Application Number: 2025/61/92242/W

RE: Hermitage Park, Lepton

This covering letter is intended to address the consultee responses provided on the reserved matters application for land off Hermitage Park, Lepton (2025/61/92242/W) submitted on Friday 8th August 2025. For ease, I have included the consultee responses in bold italic text, with our response or action listed below.

403 / GREYFORD (PLOTS 70 & 80)
PLANS & ELEVATIONS

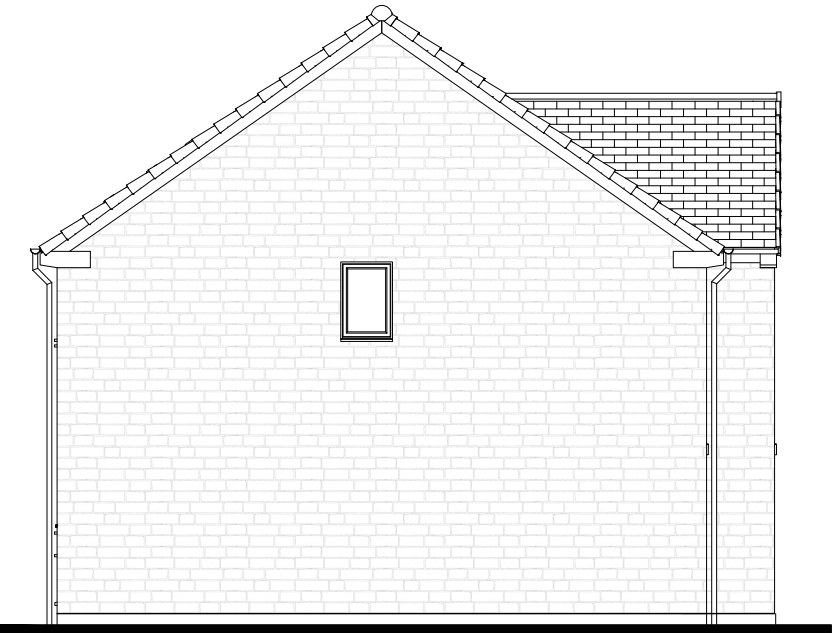
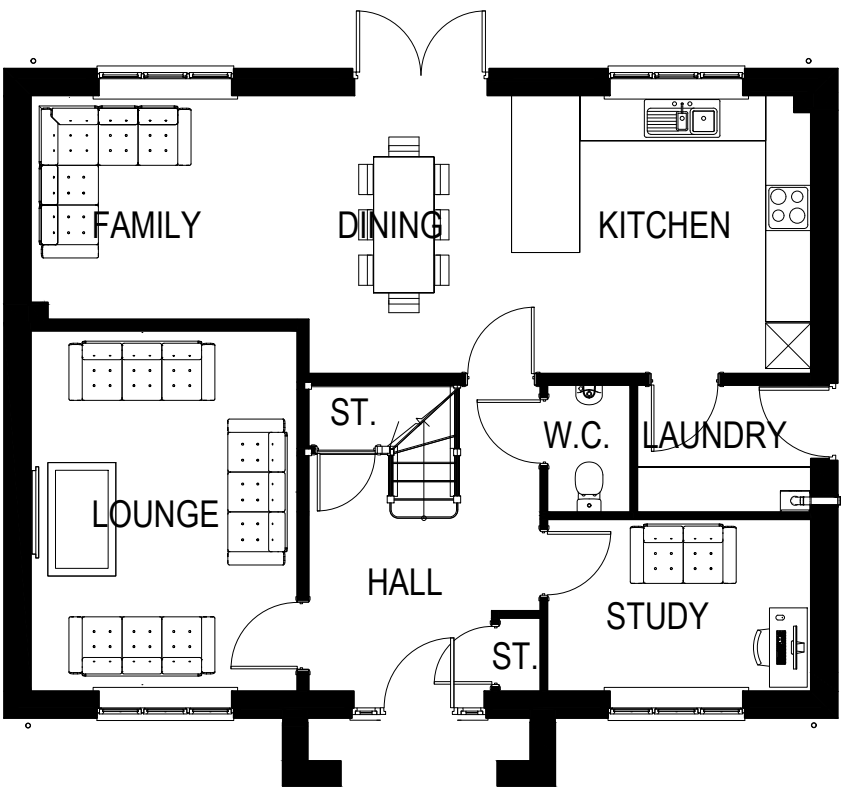
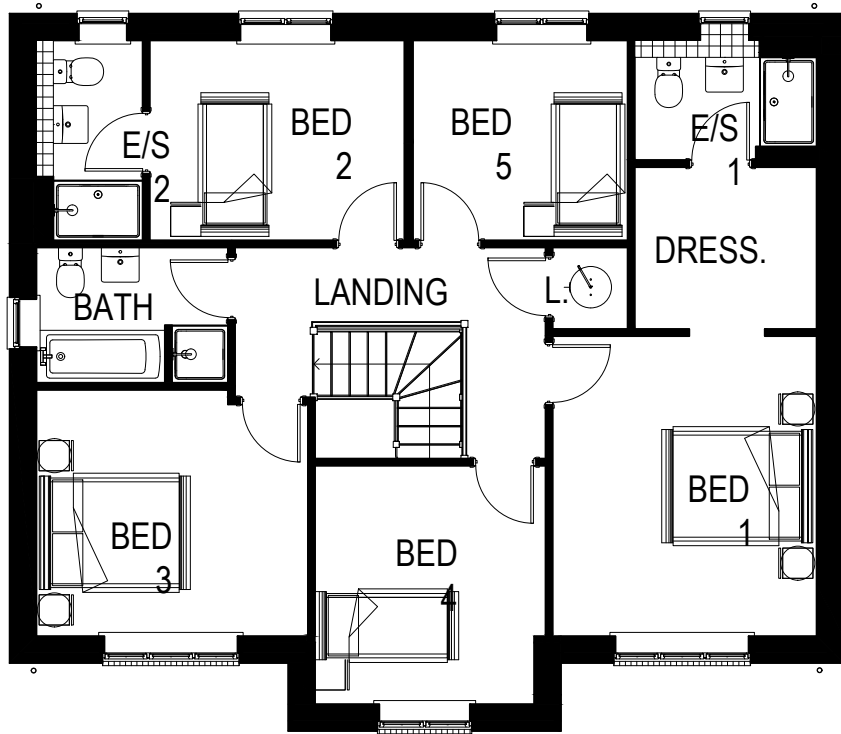
'Regarding street trees, the block comprising plots 58 to 70 looks sparse. Could more trees be added here?'

One additional tree has been added to plot 70. There are no other locations available with sufficient distance from highway and dwellings.
